PLAN REVIEW SHEET

Petition #: RZP 2021-019

Address: 355 East Woodlawn Rd.

Request: TOD-TR (CD)

REZONING SITE PLAN SCALE 1" = 60'

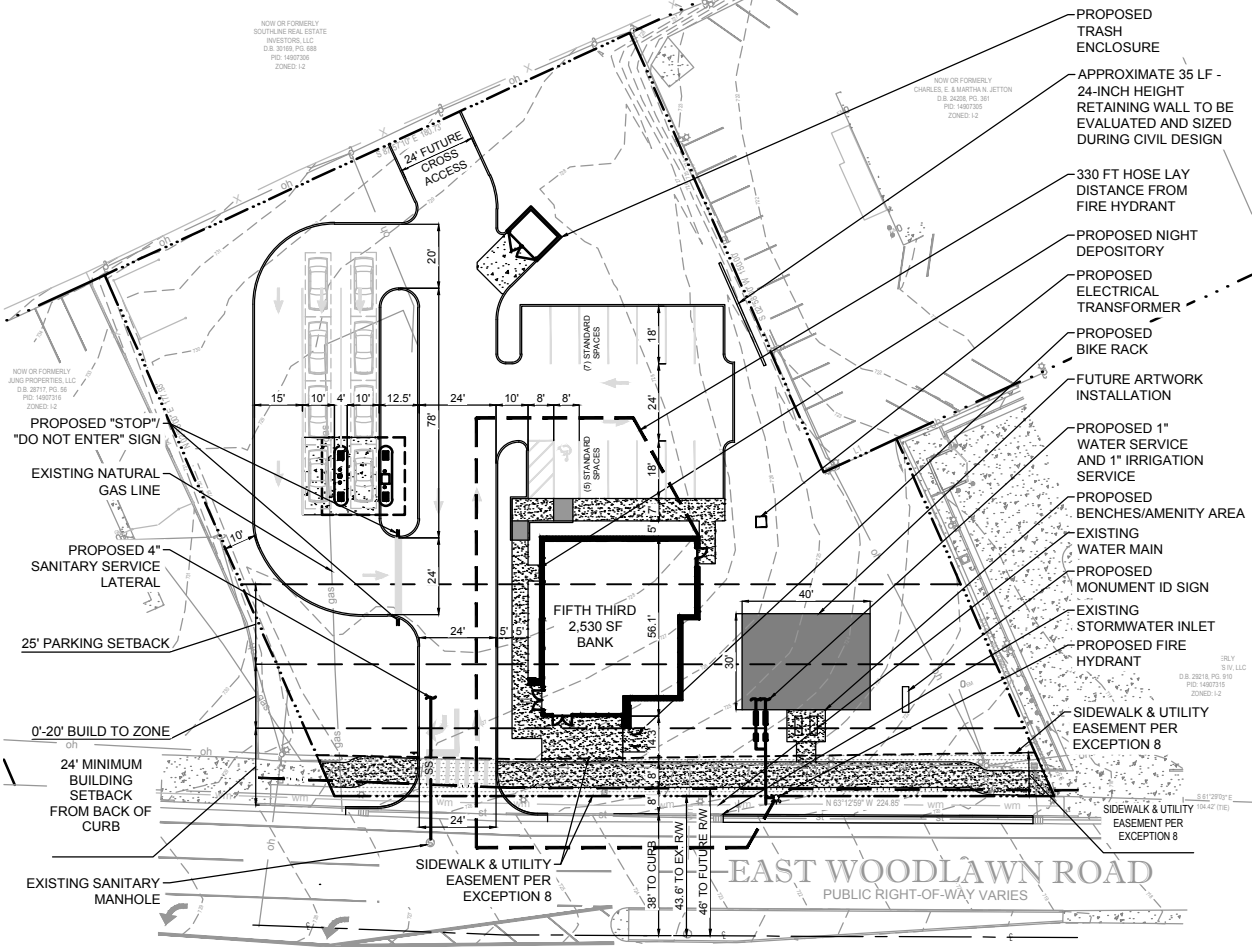
The site is located along near CATS local bus route #12 along South Blvd. and within .5 mile of the Woodlawn Blue Line Station and Park and Ride lot. The petitioner is requesting improvement of CATS bus amenities near the proposed bank location. CATS will work the petitioner and Planning to determine the location and type of improvements for community benefit as a condition of the rezoning petition.
